**KIRKLEES METROPOLITAN COUNCIL
INVESTMENT & REGENERATION SERVICE**

Reference No: 2019/62/92519/W

Site Address: 3, Cobcroft Road, Fartown, Huddersfield, HD2 2RU

Description: Erection of single storey rear extension and two storey side extension (within a Conservation Area)

Drawing
AD-A-405 - 101

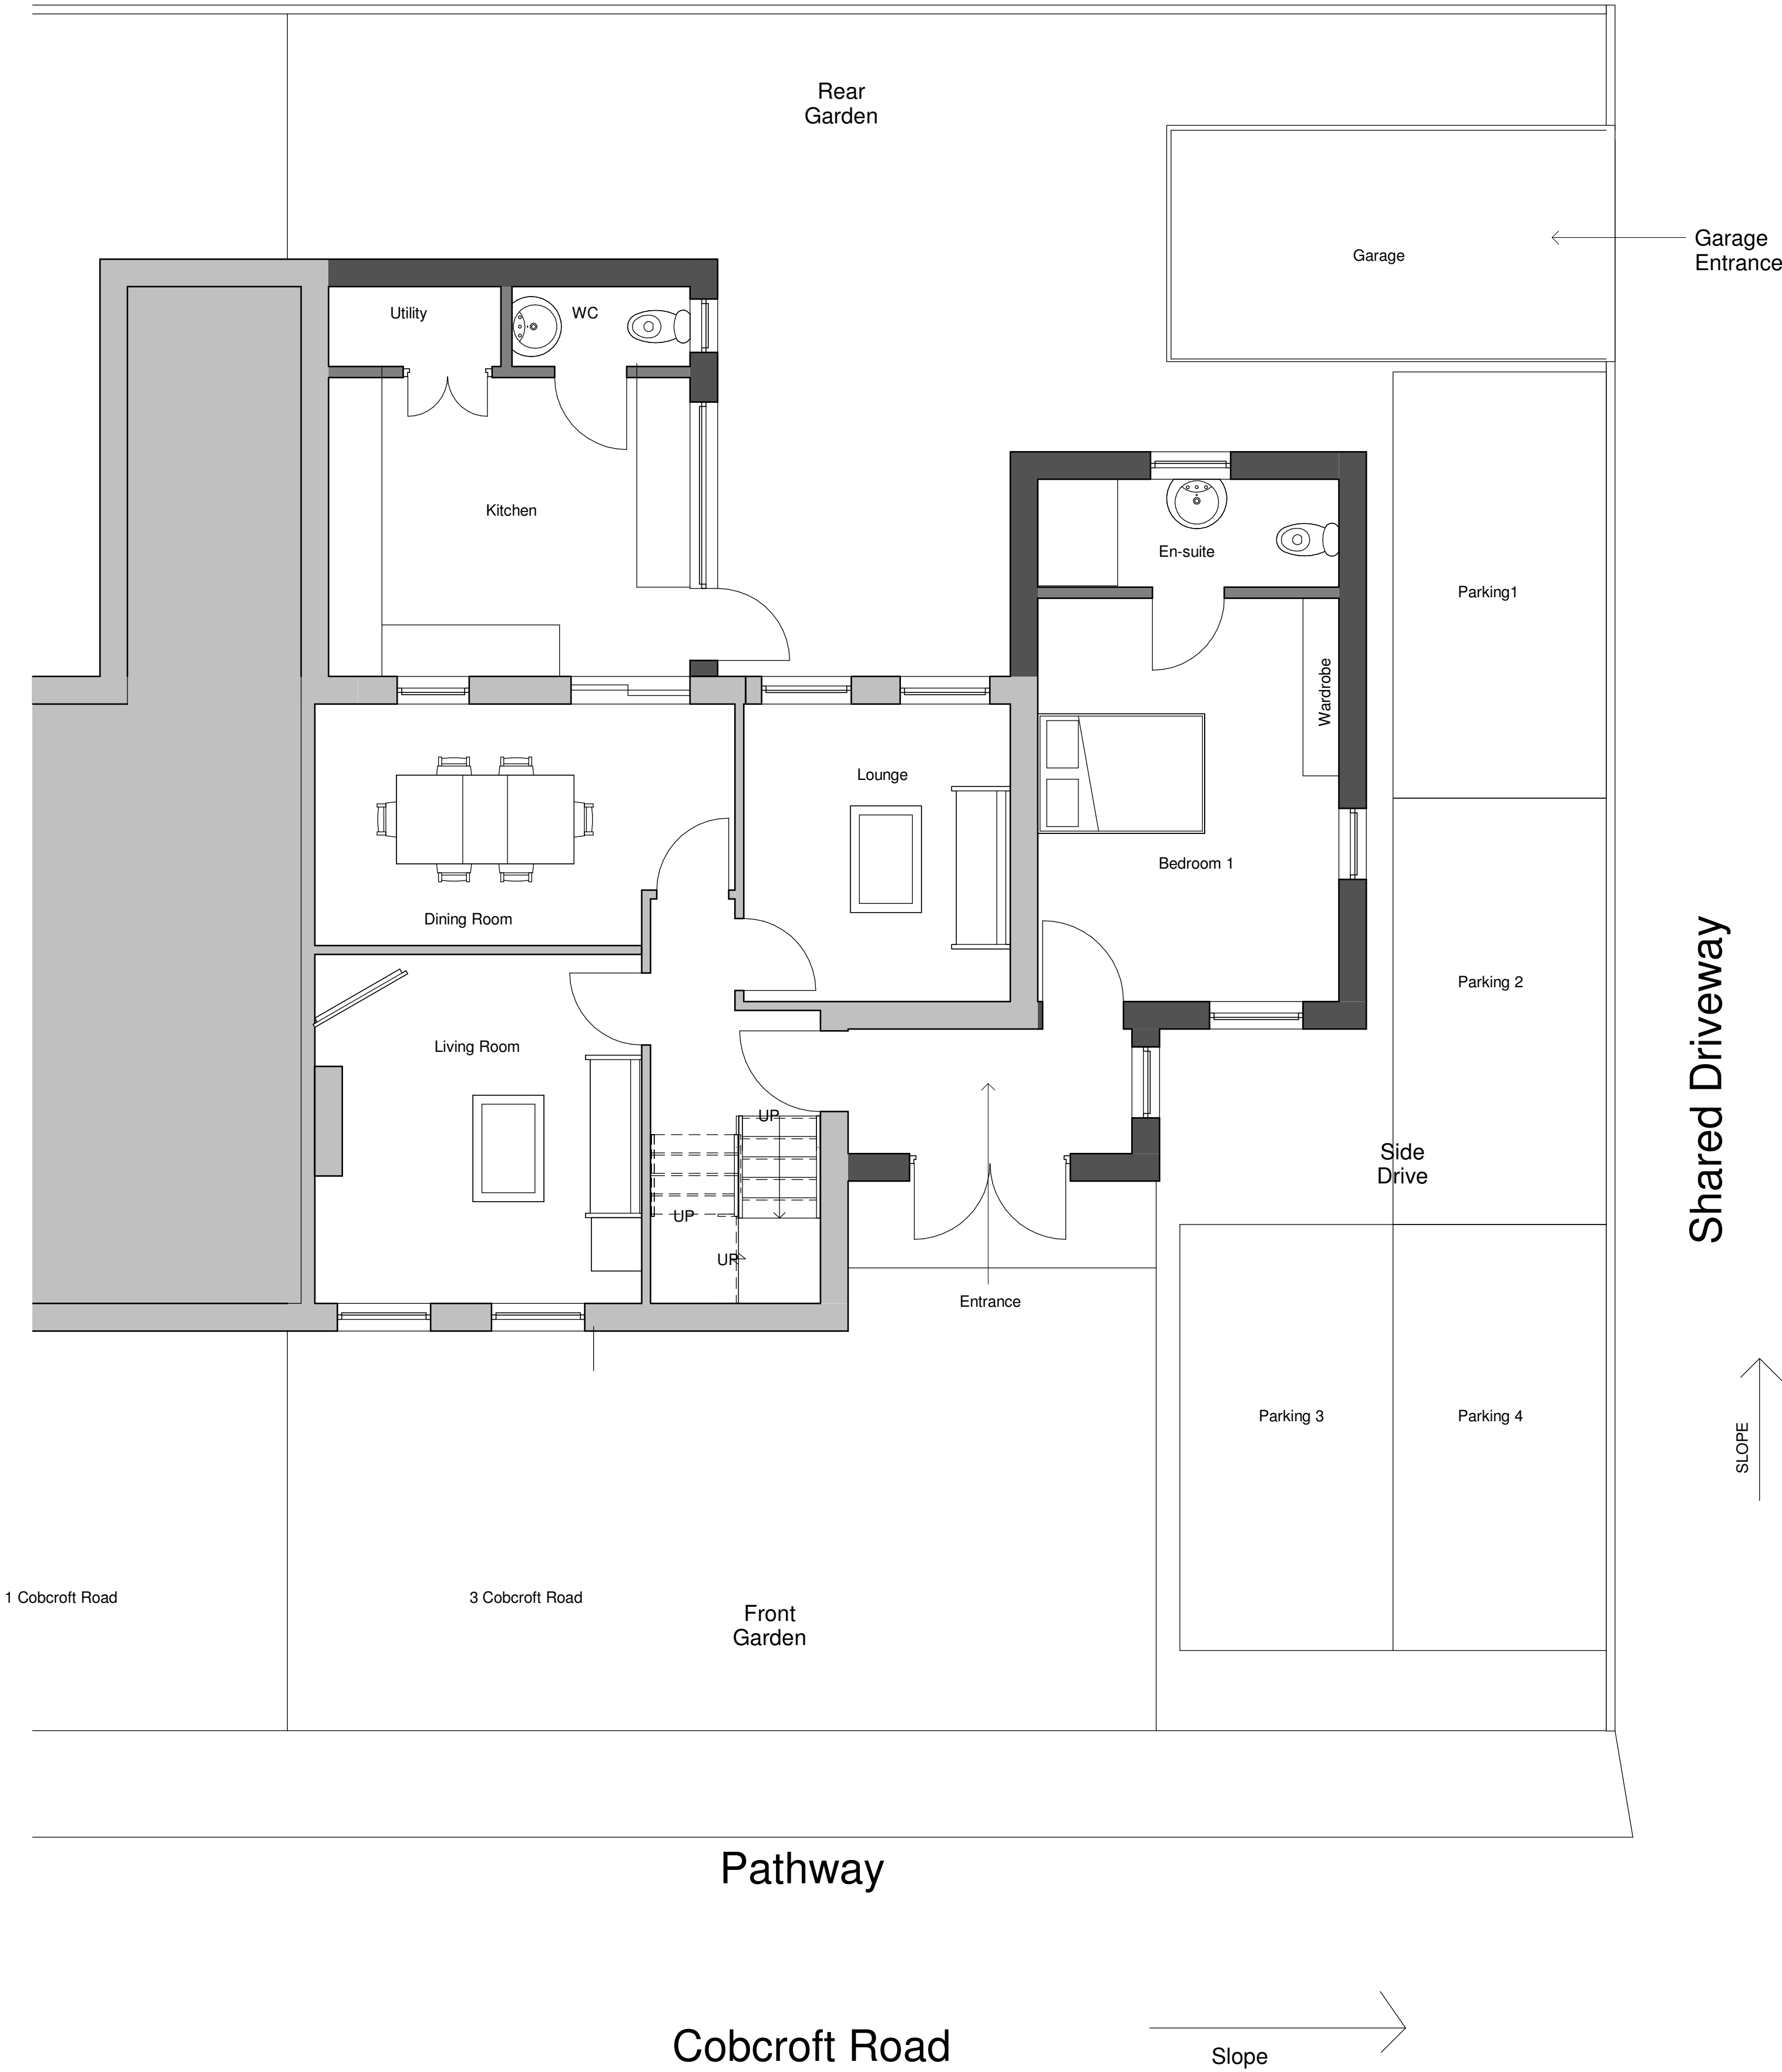
Whilst the proposal has the potential to intensify the residential use at the site, the proposed floor plan shows 4 parking spaces to be provided at the site.

4. Before the hereby approved two storey extension is first occupied, the windows within the north western facing, rear elevation shall be fitted with obscure glazing, minimum grade 4 as detailed on the hereby approved plan, Dwg. No. AD-A-405 – 101. Notwithstanding the provisions of section 55(2)(a)(ii) of the Town and Country Planning Act 1990 and the Town and Country Planning (General Permitted Development) Order 2015 (or any Order revoking or re-enacting that Order with or without modification) the window shall thereafter be so retained obscure glazed. **Reason:** So as not to detract from the amenities of adjoining property by reason of loss of privacy and to accord with Policy LP24 of the Kirklees Local Plan.
